CITY OF ALBUQUERQUE

January 25, 2013

**Re: Mesa Del Sol Community Swimming Pool
Grading and Drainage Plan
Engineer's Stamp date 1-16-13 (R16/D005)**

**GRADING AND DRAINAGE PLAN**

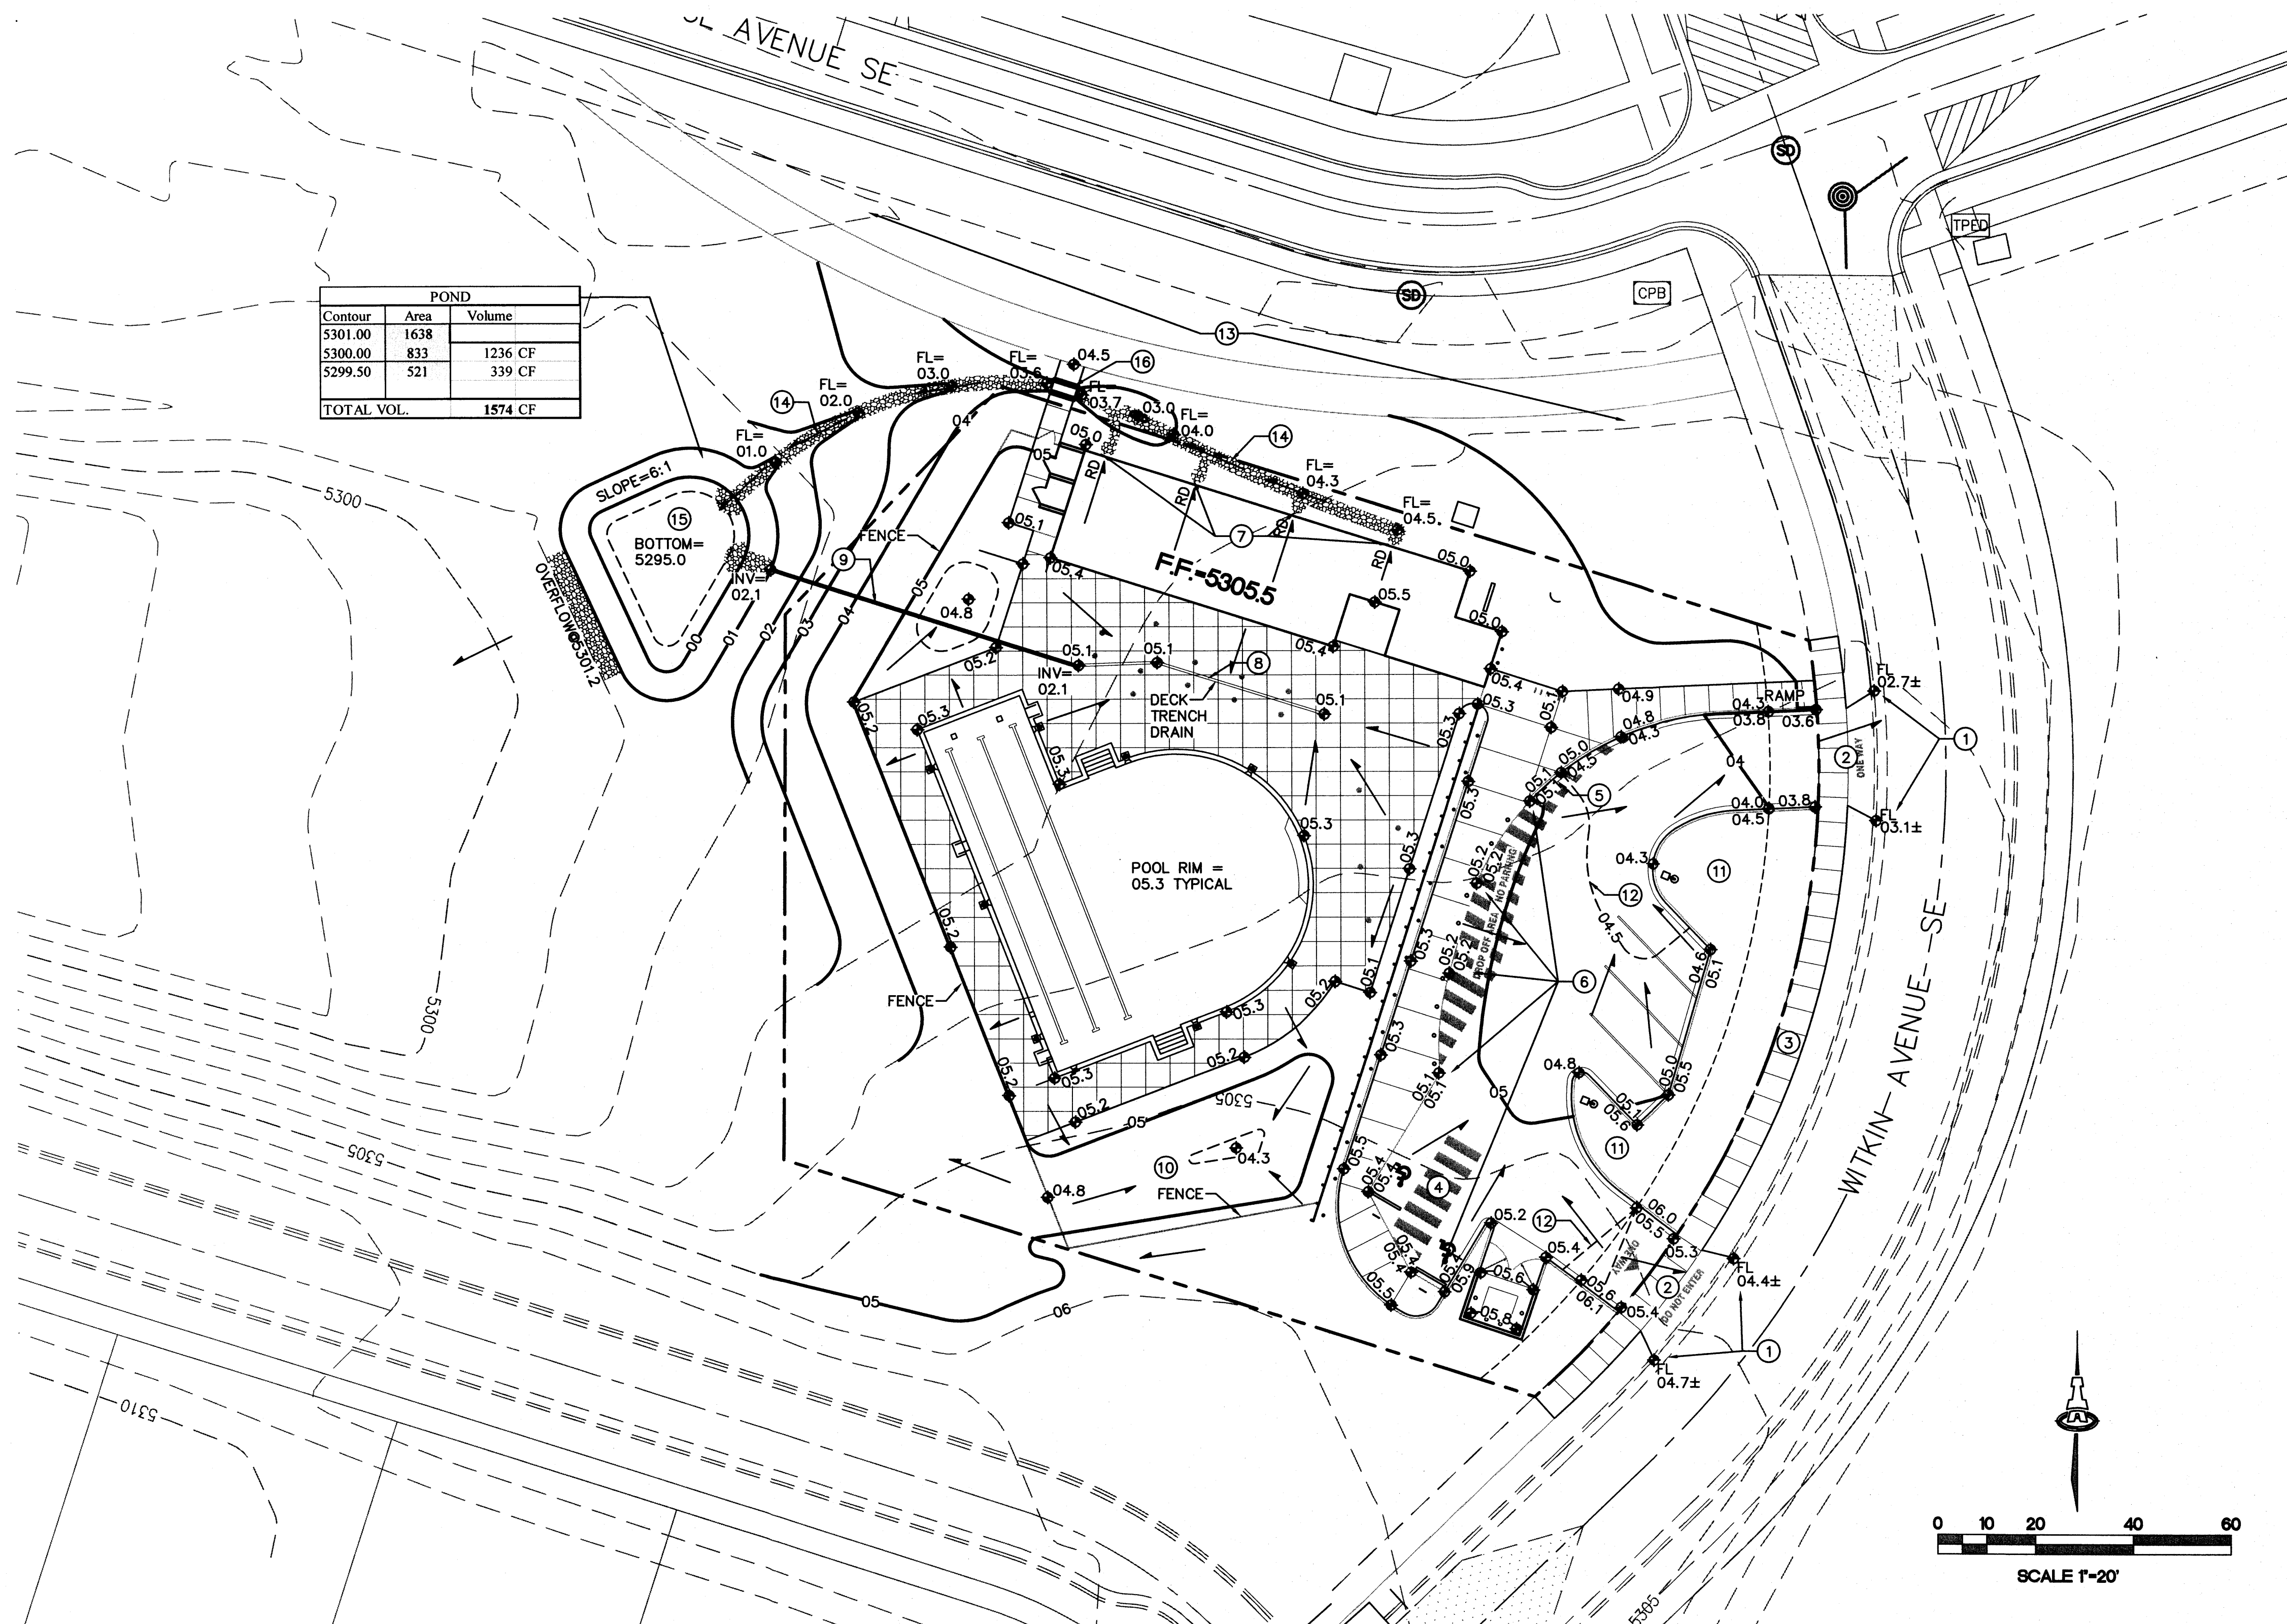
Based upon the information provided in your submittal received 1-16-13, the above referenced plan is approved for Building Permit. Hydrology is requesting that proposed landscape areas be depressed to retain/infiltrate the rain that falls on them.
